From: Ben Tidey [REDACTED]
Sent: 14 February 2018 14:58
To: Zac Denton
Cc: Ben Tidey
Subject: RE: Further Information Required on Your Ref: PP-06643594 Our Ref: Y/1/18/TC

## BERRICOURT TREE PLAN

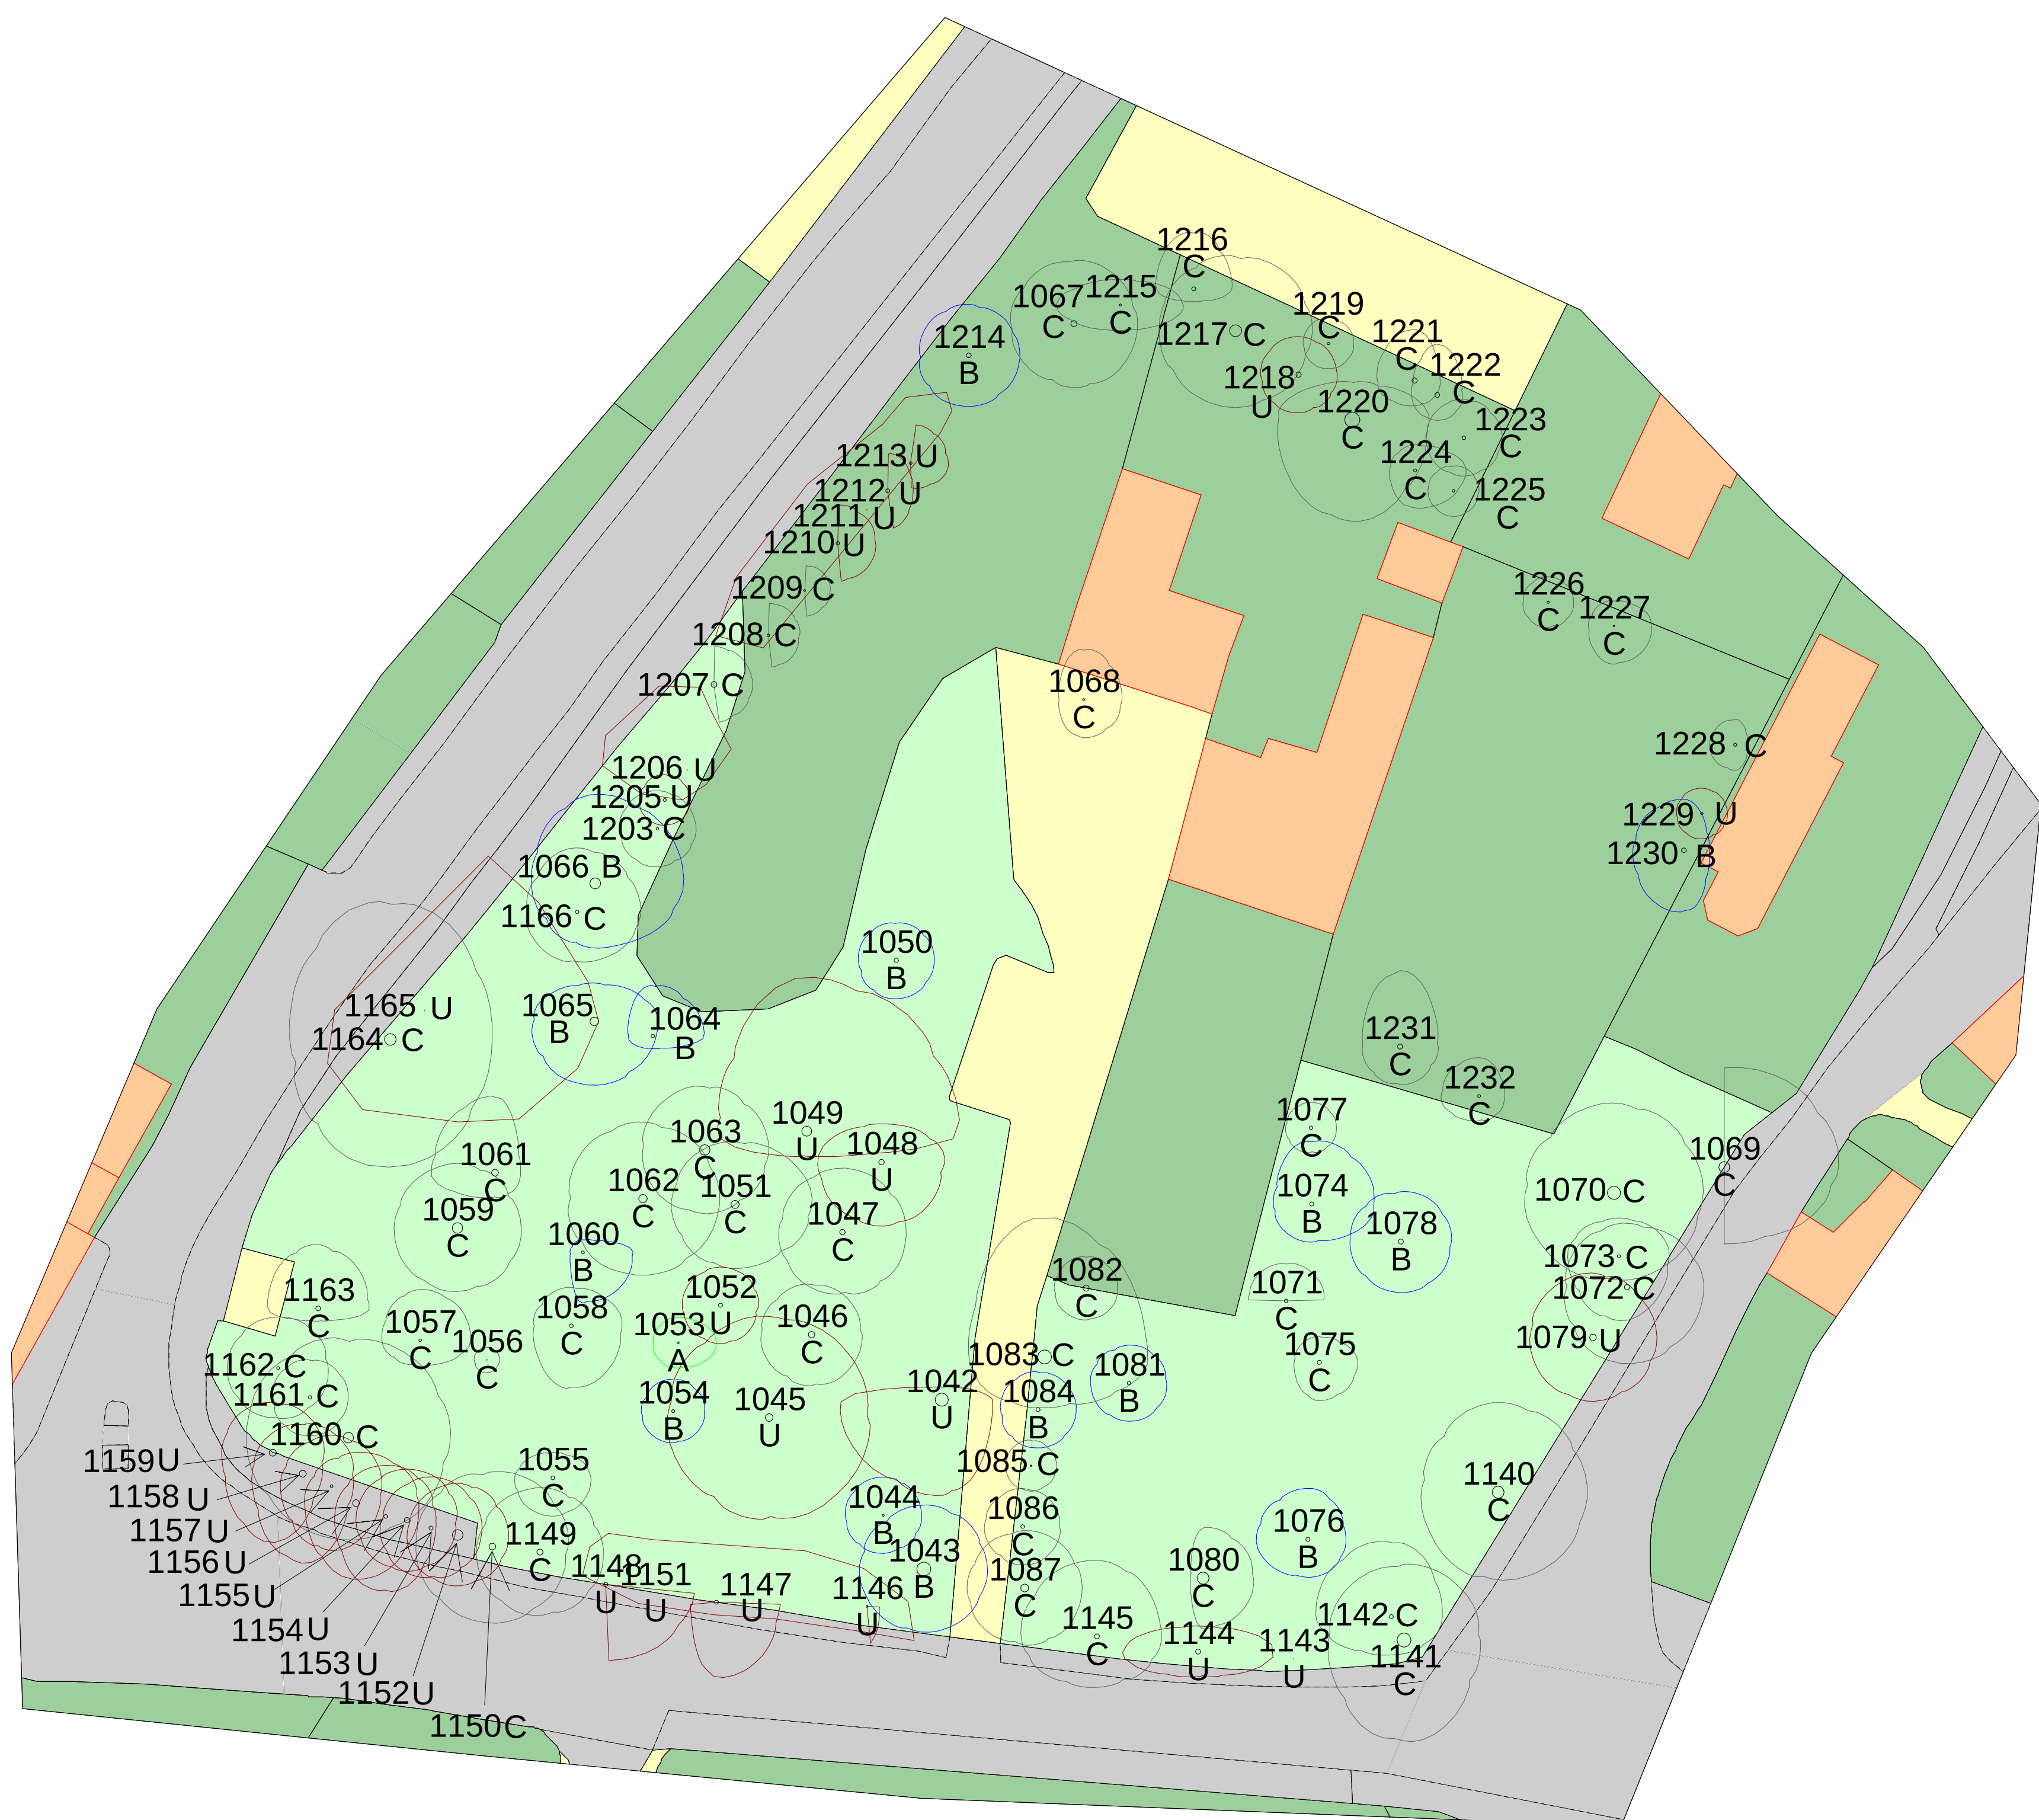
Please can you specific the measurement in metres by which you wish to reduce Tree 1068, additionally, a measurement in metres stating the crown lift distance you wish to perform to Tree 1140.

1068. Cut back from building by 1m.

1140. Crown lift over road to 6.5m over road and 3.5 over payment.
